Response to Submissions and Amendment Report

Infill Affordable Housing
Development – Edmondson Park
Block 20a

SSD-99909708

Figure 1
Typical floor plan overlay with red circle highlighting areas where interface conditions of windows and balconies should be reconsidered

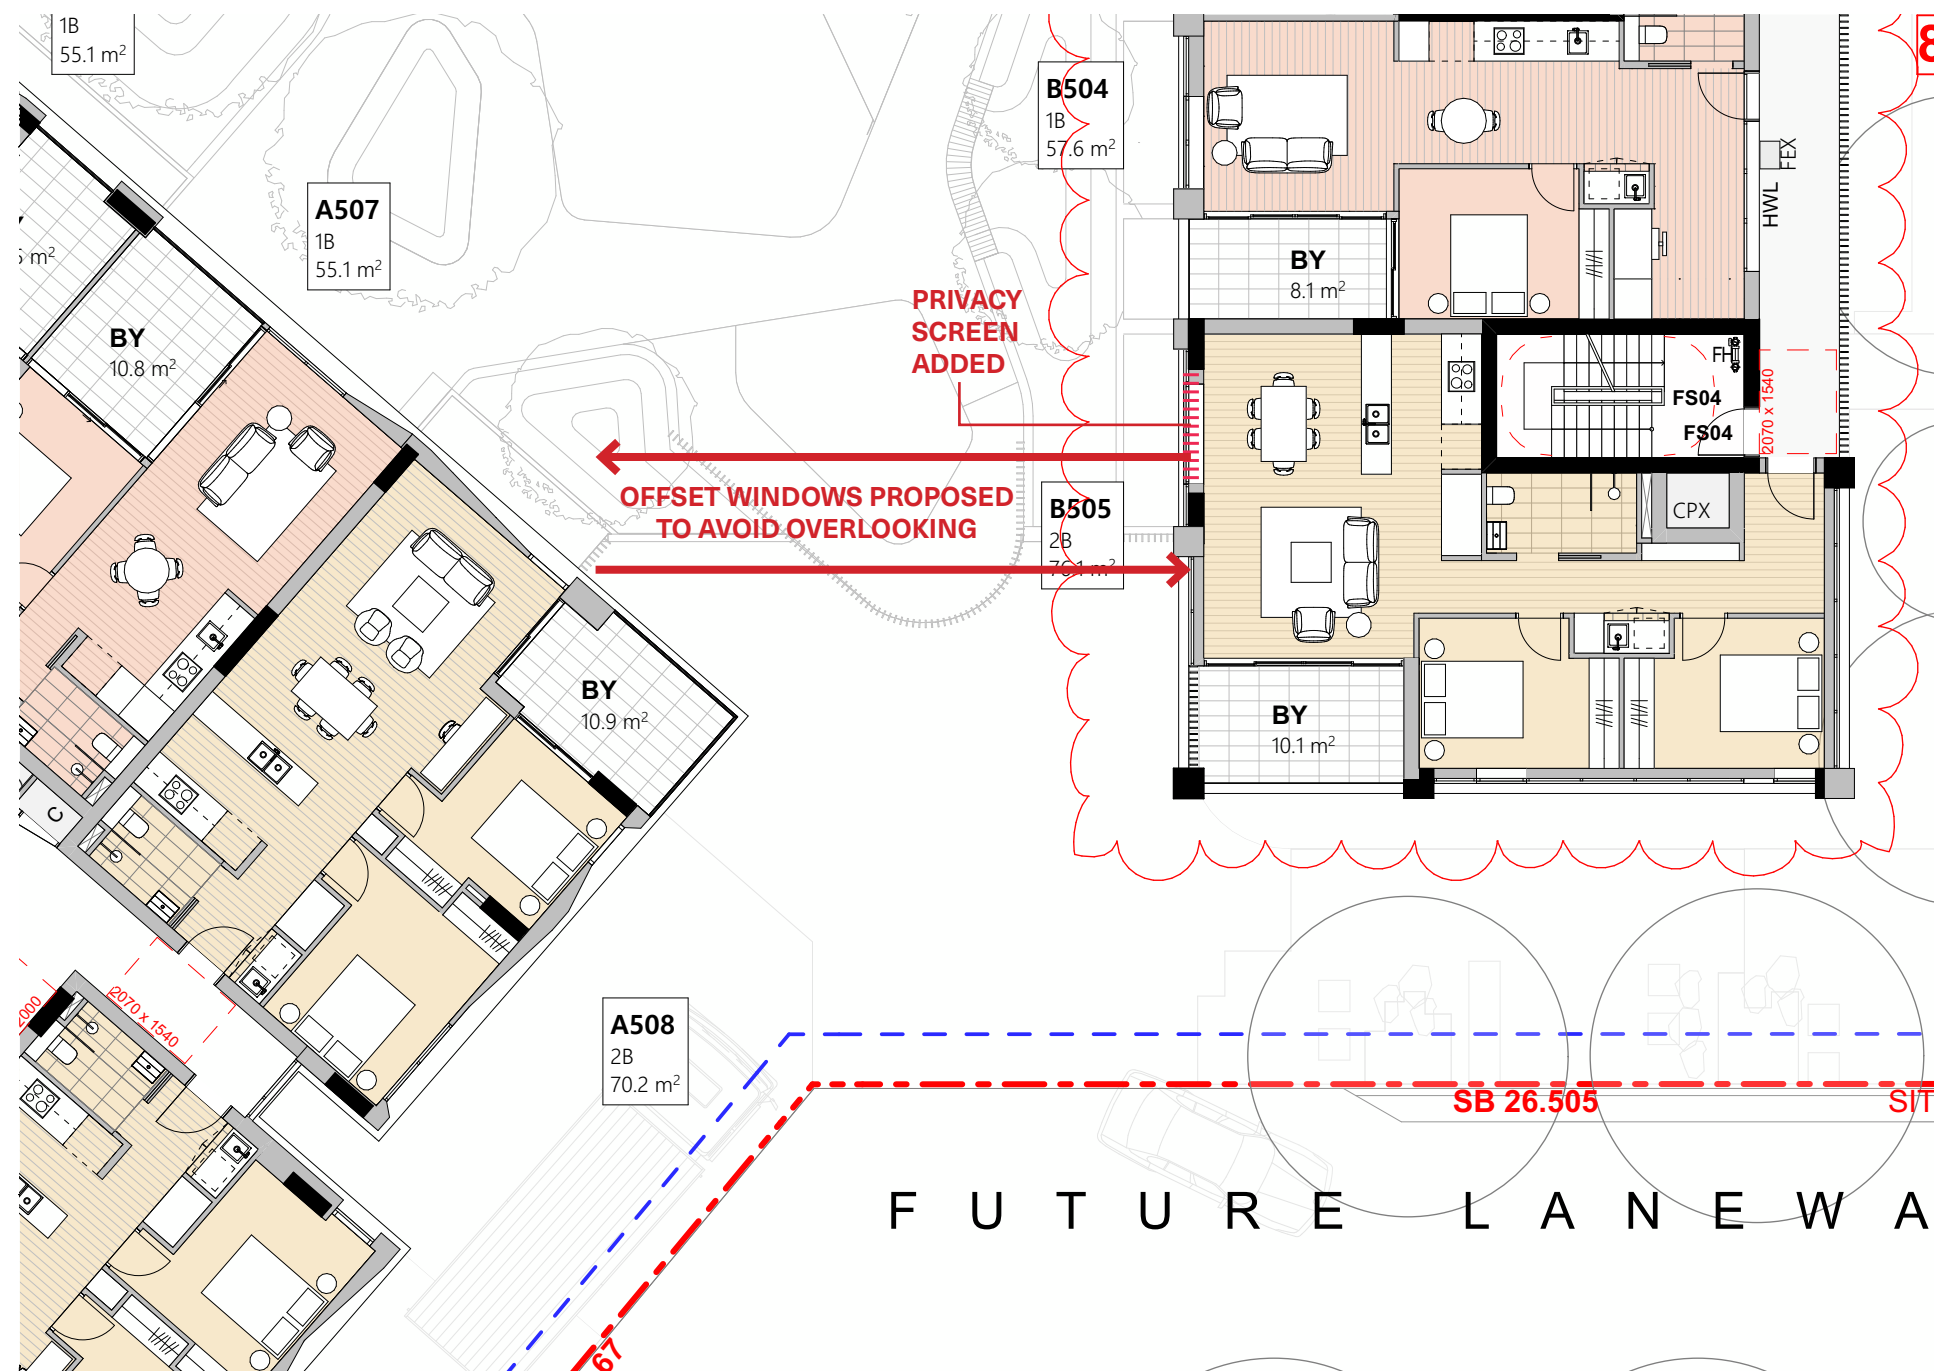
Issue Raised	Response
Building Separation	
Consideration being given to increase the proposed building separation distance between Building A and Building B at the southern junction and edge of the development boundary as the separation distances currently do not comply with the Apartment Design Guide (ADG).	The Design Team have reviewed the siting of the development especially the relationship of both buildings at the southern junction. Minimum separation distances between buildings is encouraged in accordance with Part 3F of the Apartment Design Guide (ADG). This section of the Guide aims to ensure the siting of the building/s maintain appropriate levels of visual privacy between properties. Design criteria require separation distances of a minimum of 12m between buildings up to 4 storeys and 18m (5-8 storeys). Building A and Building B at the closest point have a

total of 9.3m which fails to comply with the minimum separation distances.

The design has been refined to ensure windows openings and balconies are offset and an external angled louvred privacy screen is proposed to the lounge room window to the southern most units in Building B (205, 305, 405, 505, 605, 705 and 805) as shown in Figure 1 below. The balconies to these units already include privacy louvres which will restrict any overlooking. Figure 1 below shows the proposed design response to this issue.

SUBSTATION OPTIONS EXPLORED

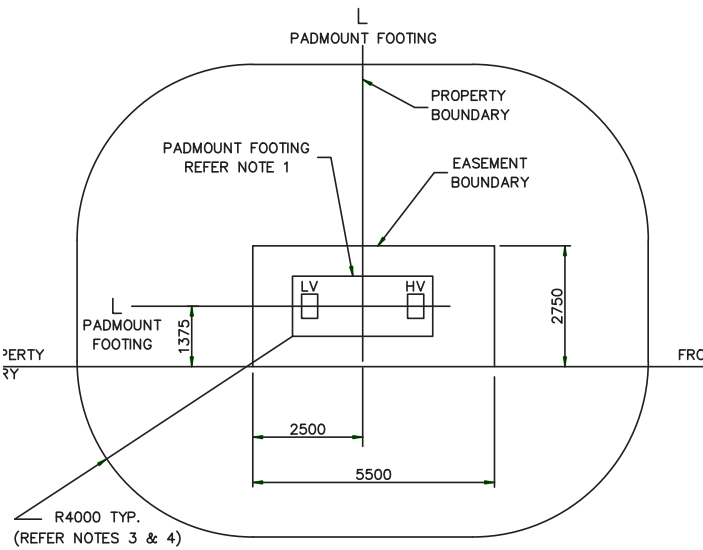
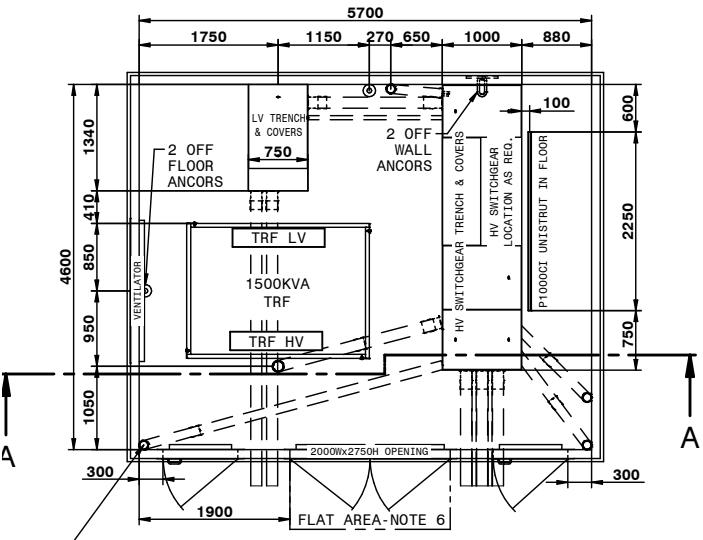
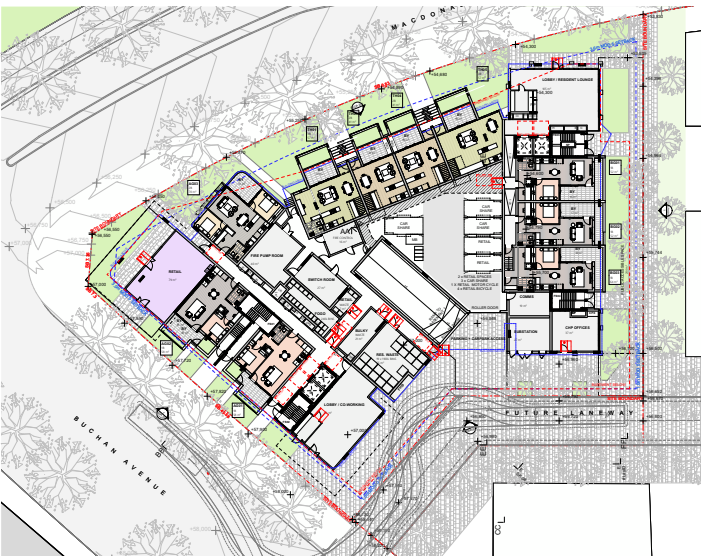
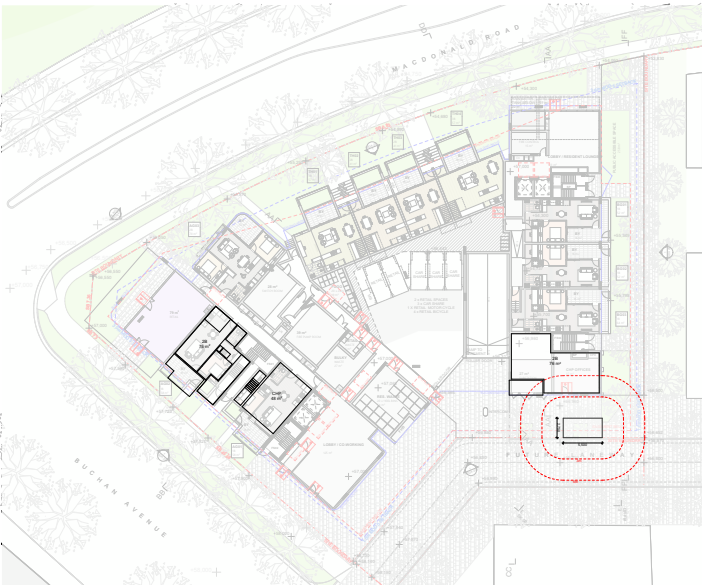
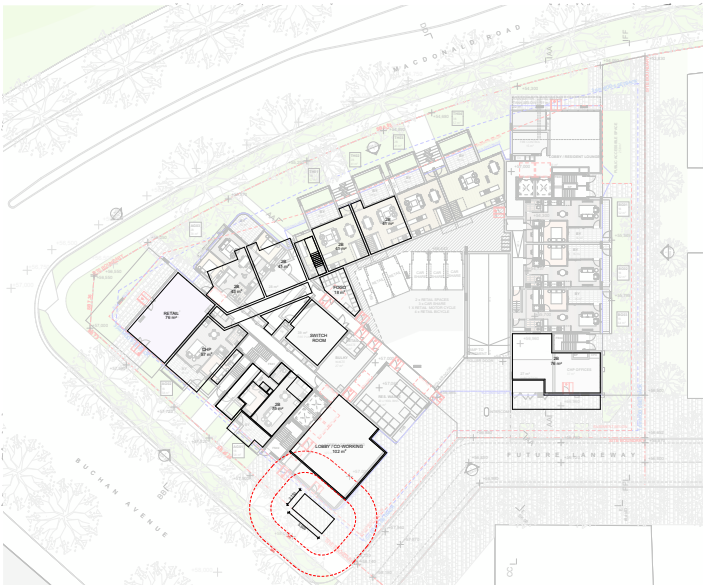
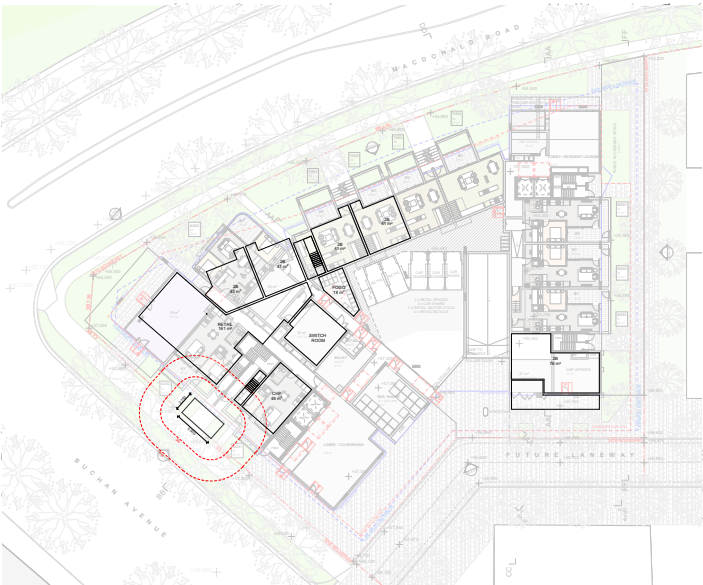
The location of the electrical substation along Buchan Avenue frontage should be reconsidered as it will impact the residential amenity of the units and visual presentation of the development to the streetscape.

The Applicant explored a number of alternative locations and types of the electrical substations. Initially it was designed as a mini-chamber to be located centrally off the laneway. While this was a more desirable design solution it is cost prohibitive. The current location is the most feasible option as the existing Endeavour Energy (EE) HV network is located along Buchan Avenue which allows for easy connectivity and saves money on extending the existing network. In addition, EE standards require the substation to be located at the front boundary with 24/7 access from a public street. A proposed indoor substation location does not satisfy these provisions. There are also many logistical issues with a substation located centrally off the laneway, EE access arrangements are more complex as heavy vehicles need to be able to access the substation for repairs, maintenance and/or major equipment replacement etc. Locating the substation off the laneway will require appropriate easements to be created for access etc. An indoor chamber costs approximately \$350,000 when compared to \$200,000 for a padmount station. In this case, the current location is the most viable, economically feasible and convenient. A more detailed

Issue Raised	Response
	explanation of the benefits of the current location of the padmount station is provided in the design response, and an exploration of all the potential options is included in the report at Appendix C. To improve the visual presence of the substation it is being considered (and subject to EE approval) to include some indigenous and/or public art which is a common feature of many of these structures. This will improve the visual amenity and presentation of the structure and create a more sculptural element as opposed to a utility and infrastructure installation. Examples of substations incorporating public art are included in the report at Appendix C. The inclusion of some low scale landscaping and vegetation behind the structure will screen it and provide a green buffer between it and the adjoining apartments. This design solution is considered an acceptable and reasonable response that will not result in a poor urban design and streetscape outcome.

Updated basement plan

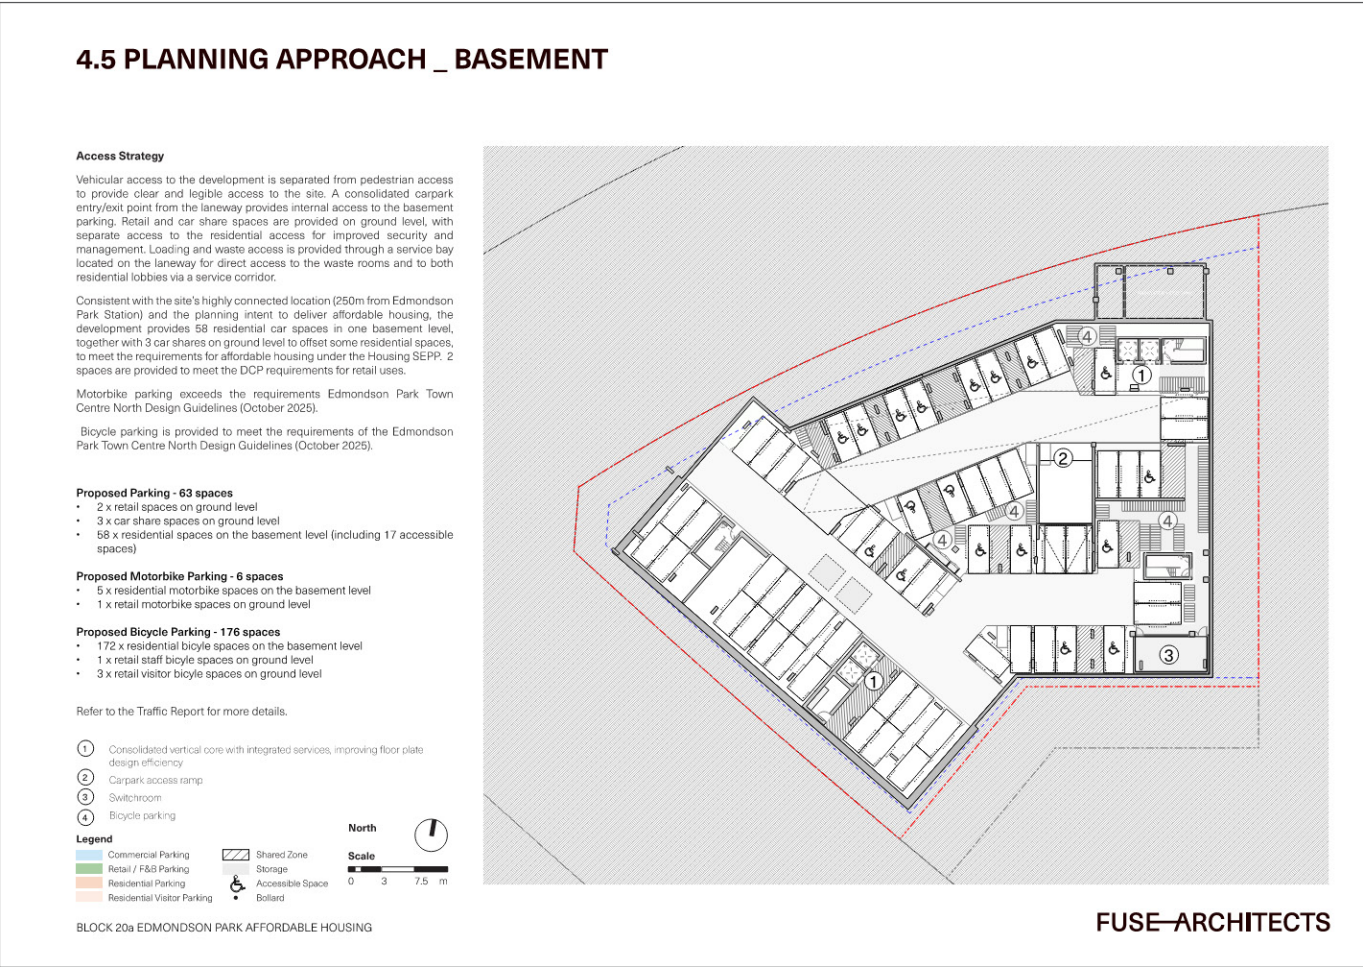
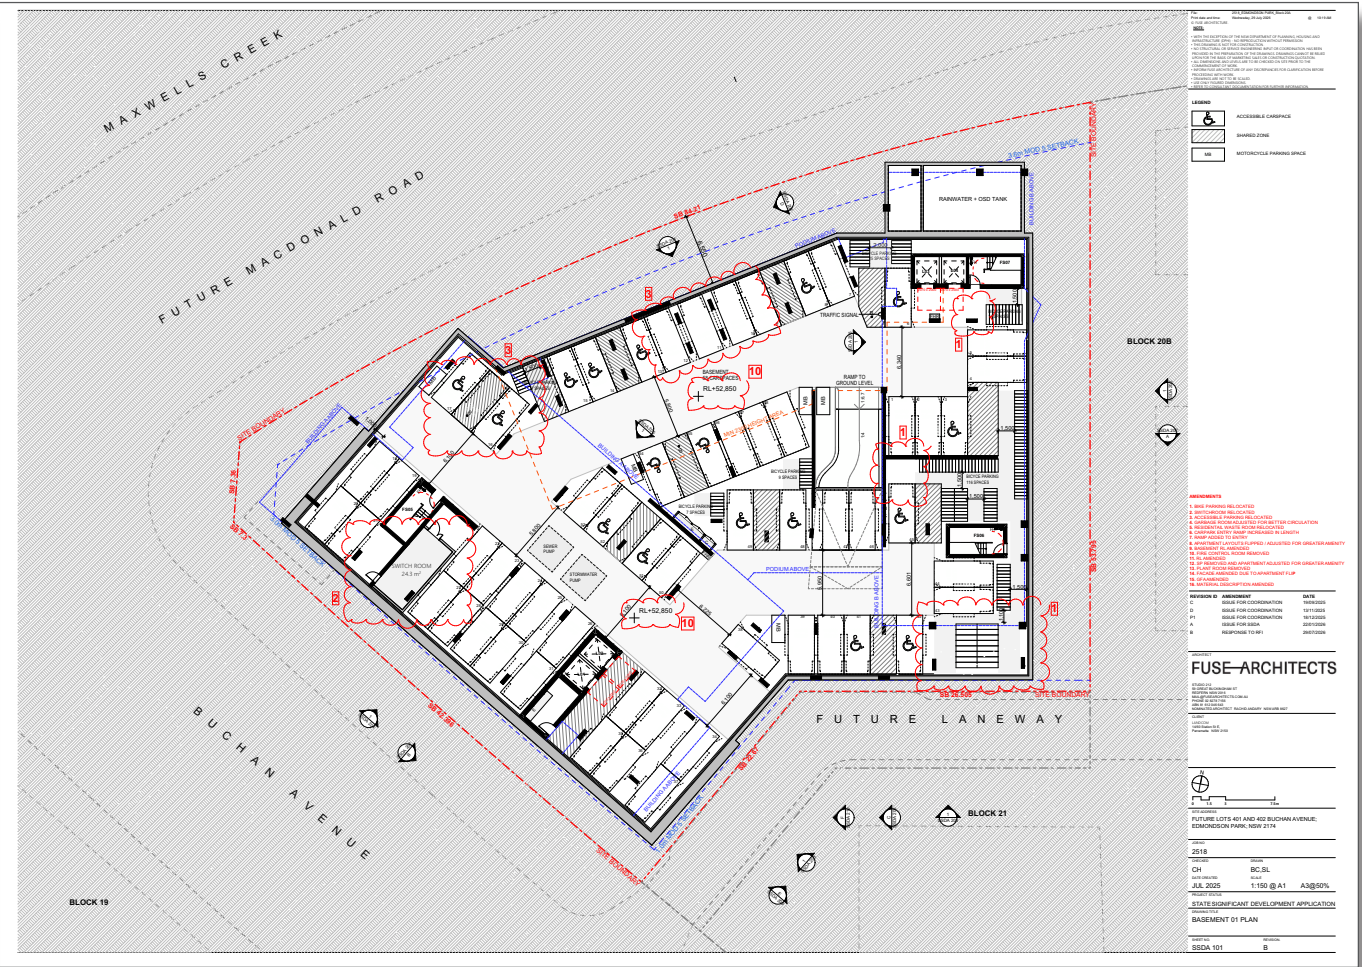
Basement car parking design	
Some basement car parking spaces are overlapping, and the architectural plans are inconsistent with the Design Report.	Basement Plan 01 shows car parking spaces No.38, 54 and 58 overlapping with adjoining spaces and walls. DPHI request that all parking spaces comply with the minimum dimensions and do not intersect with other components in the basement. The plans have been updated to ensure all car parking spaces comply with AS2890 and no longer intersect with other components (car parking spaces, columns or walls) in the basement.
Inconsistencies have been identified between the Design Report and Basement 01 Plan regarding the location of the switch room, bicycle parking and storage.	The Plans and Design Report have been reviewed and plans updated to ensure there is no inconsistency in the details provided. Refer to Appendix B and D . The switch room has been relocated towards the eastern side which has freed up the space along the western side creating a consolidated bicycle parking area.
